## 605 Stevens Ave - Code

1 | THIRD FLOOR LIFE SAFETY PLAN  
1/16" = 1'-0"

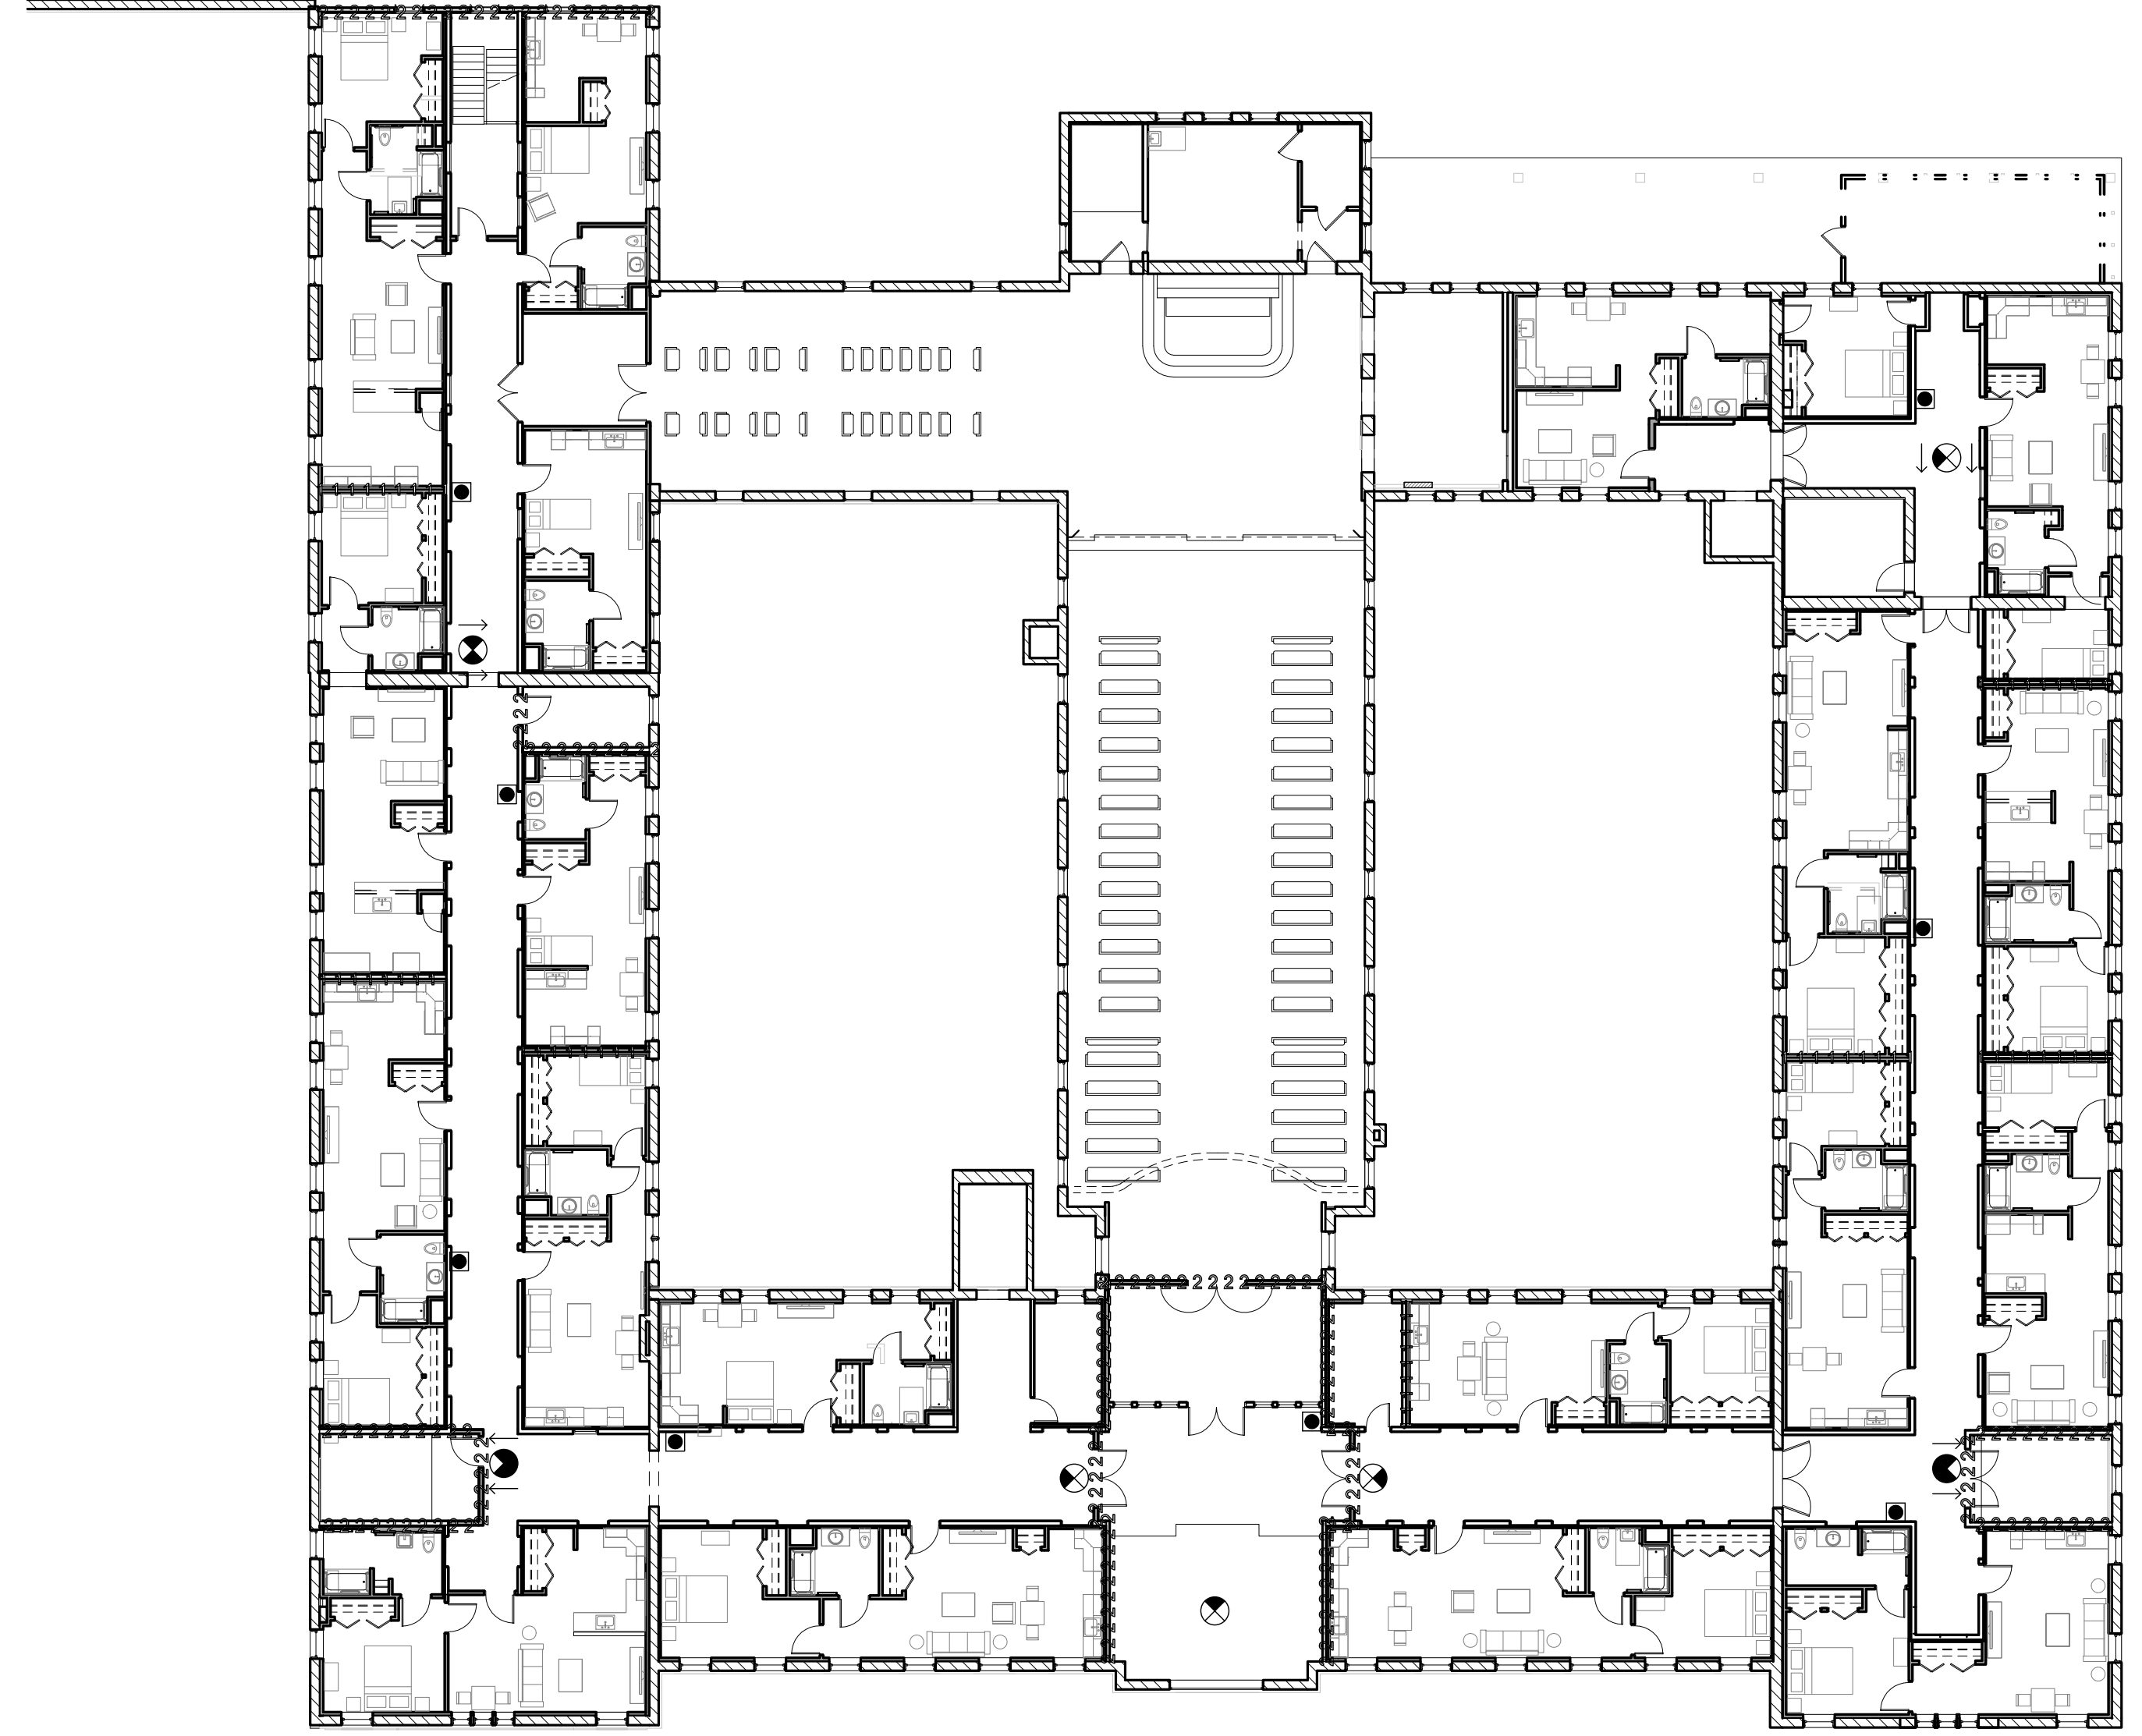
When Craig and I did the walk through, there was some discussion as to the use of the assembly space. This remained rather unclear after we asked this. Could you remind me of the proposed use?

One other question is the pews. Would they remain existing? Directly, what I am getting at is the occupant load. Can you tell me the existing OL, and what would be the possible OL?

Thanks for the follow-up and the phone call. As discussed, we are still unclear on the actual use of the space, but we assume it will continue to be an assembly occupancy. The pews will remain.

The current occupant load, based on 15 sq.ft./person is 339. As discussed, it would not be a problem for us to have you post the occupant load at 299, to keep it below the NFPA threshold for occupants found in Table 13.1.6, X4, when dealing with building height.
